Application No: FG/142/20/HH
Site Address: 22 The Poplars Ferring BN12 5QL
Description of works: Single storey rear extension with mono pitch sloped flat roof

RE: Planning Application FG/142/20/HH. 22 The Poplars, Ferring, BN12 5QL

SECTION. PROPOSED.

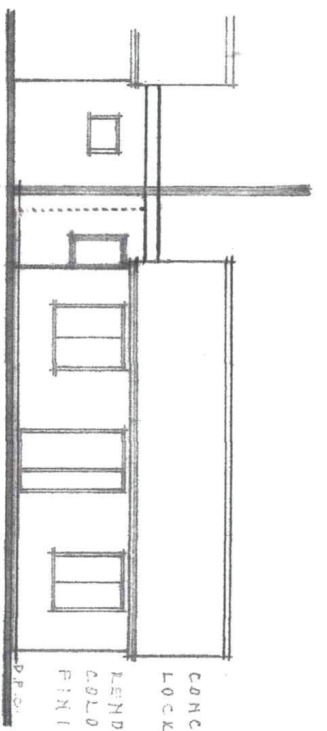
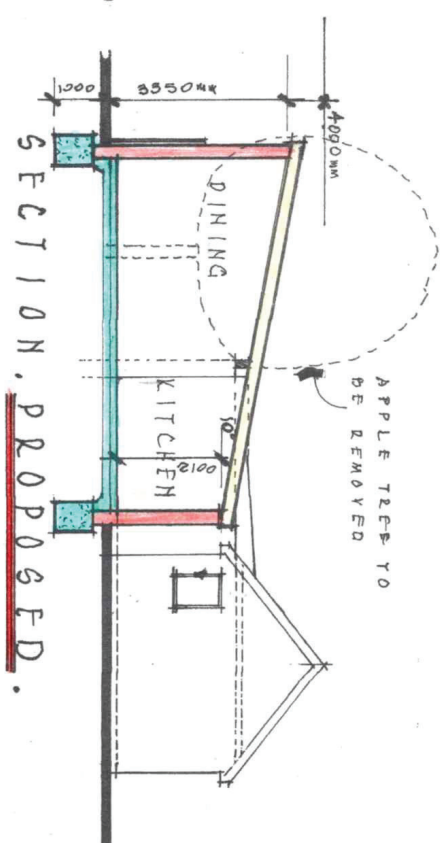
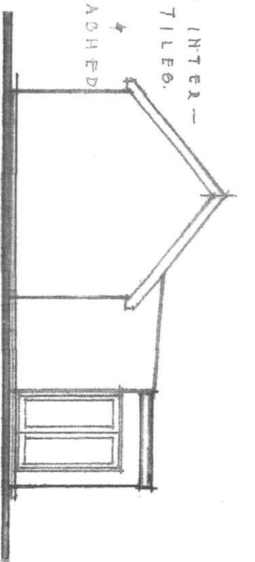
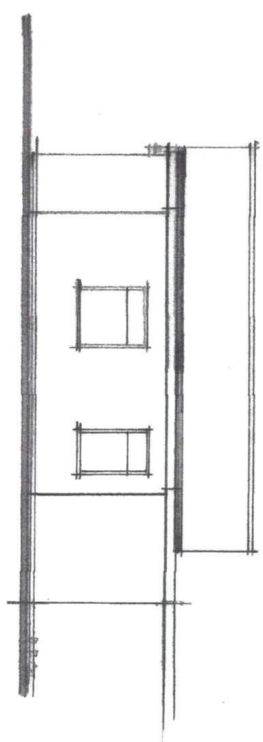
Our main concern is a structural one - demolishing the single skin walls of No. 22 and digging out footings for a new cavity wall as shown on the proposed plan may well damage our bathroom walls with their enclosed water pipes and tiling. We need to protect our tenant from this: putting the only bathroom out of commission for repairs would require the re-housing of our tenant. We believe it might be possible to undertake the work and minimize risk to us if the builder draws up and follows a suitable procedure agreed with building control and ourselves. We will require a Party Wall Agreement, a risk assessment and a schedule of works to be in place before work commences as well as a proposal from the builder as to how the tenant's car parked on our driveway will be protected. The builder needs to be fully insured including cover for temporary accommodation if it becomes necessary. We would also request that the builder informs us as to the start date so we can be present to witness that no damage occurs to our property.

EXISTING FLOOR PLAN.

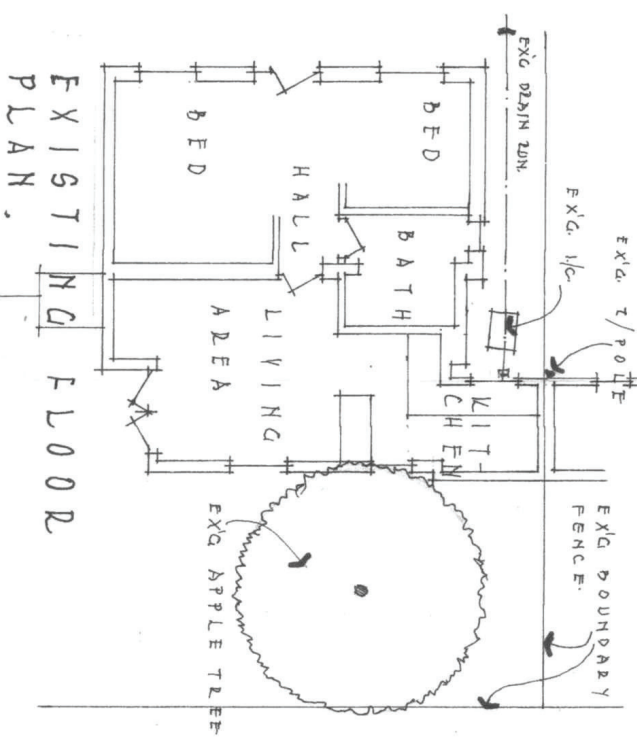
We have some grave concerns, not with the overall plan, but with the detail and how the construction work is likely to cause damage to our property. The existing plan also shows that a small corner of our property would be built over (the existing and agreed boundary is not shown correctly on the proposed plan). This we are open to negotiation/agreement on as detailed below as we have no wish to be obstructive to the development.

On the issue of encroachment of the proposed new walls onto our land/ parking area, we assume the existing

East side boundary hedge will have to be removed for access to undertake the work. In return for us agreeing to the proposal we will require the erection of a 3 ft high wall or fence running along the existing hedge line on the East side before completion of the work to re-establish separation of the footpath from our driveway.
